<b>Application No</b>	<b>SSD 7036</b>
<b>Location</b>	Seelems Road, Coraki
<b>Applicant</b>	Quarry Solutions Pty Ltd
<b>Council Area</b>	Richmond Valley Council
<b>Consent Authority</b>	Minister of Planning

Thank you for the opportunity to comment on the proposal for the new Coraki Quarry.

Council has reviewed the EIS in preparing a number of comments and suggested conditions that Richmond Valley Council believes are appropriate to the application for the new quarry, particularly given the scale of operations.

Figure 3: Road Network and Transport Route

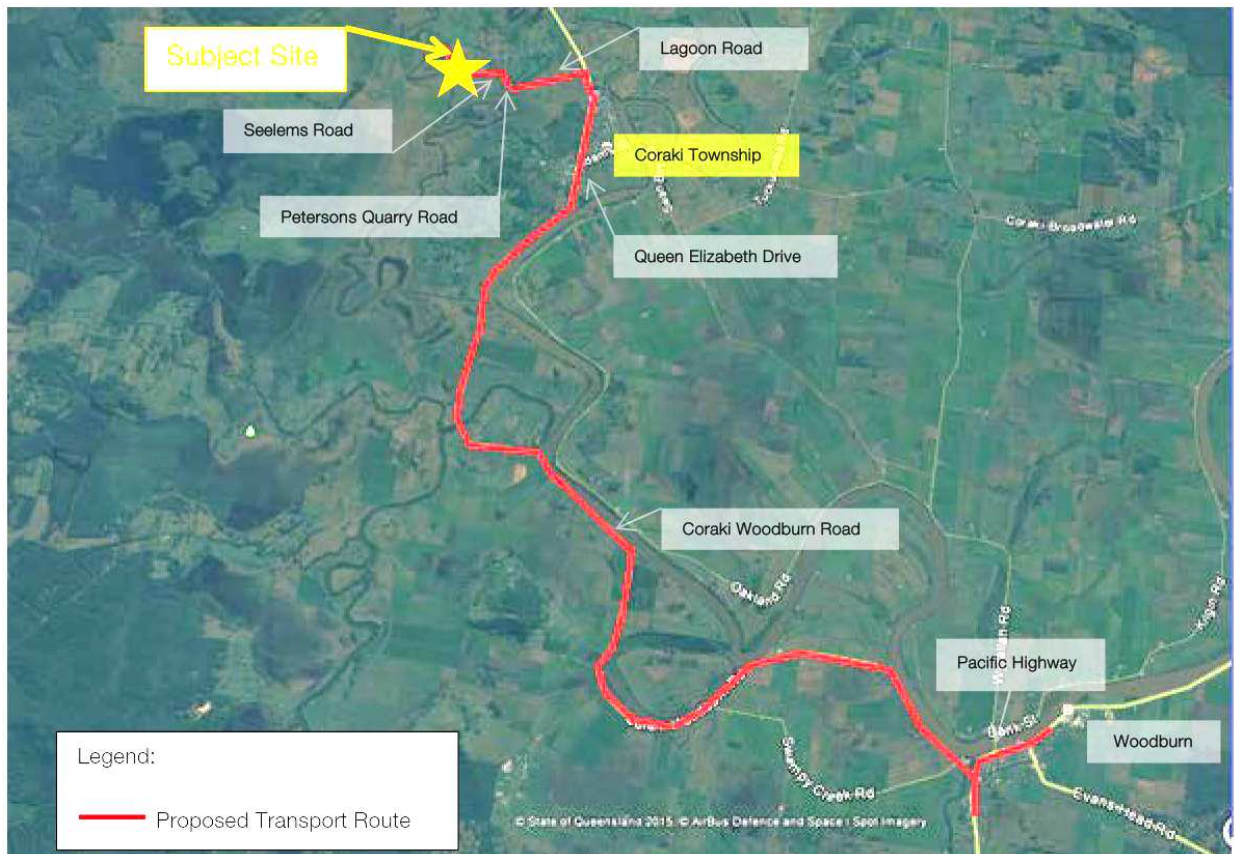
Council is extremely concerned about the severe impacts that will occur on the Woodburn Coraki Road. The road was constructed (sealed) in the early 1950s with the original construction not being to modern standards. The road already shows distress due to current traffic loads. The road is also on a very large floodplain and is susceptible to flooding. The use of heavy vehicles over a saturated pavement is a recipe for complete destruction of the road. Council reserves the right to impose temporary load limits (or exclusion of heavy vehicles for a period) on the road that has suffered inundation.

Council believes that the large amount of heavy traffic on the gravel Seelems Road will present an unacceptable amenity issue for the existing house at 200 Lagoon Road. Wind roses from the Bureau of Meteorology website show that there is a

The traffic loadings detailed in the EIS are understated by the use of an average over the full hours over the whole year (50 weeks). The actual impacts on both the community and the road infrastructure will be much greater.

1. Seelems Road is to be constructed and sealed as a 6 metre two coat bitumen seal with 1 metre gravel shoulders from Petersons Quarry Road to a point 200 metres west of the entrance to the industrial building at 30 Seelems Road.
2. The Petersons Quarry Road / Lagoon Road intersection shall be sealed with AC/hotmix for heavy vehicle tyre drag control.
3. The Lagoon Road / Casino Coraki Road intersection shall be sealed with AC/hotmix for heavy vehicle tyre drag control.
4. The Woodburn Coraki Road / Pacific Highway intersection shall be sealed with AC/hotmix for heavy vehicle tyre drag control.
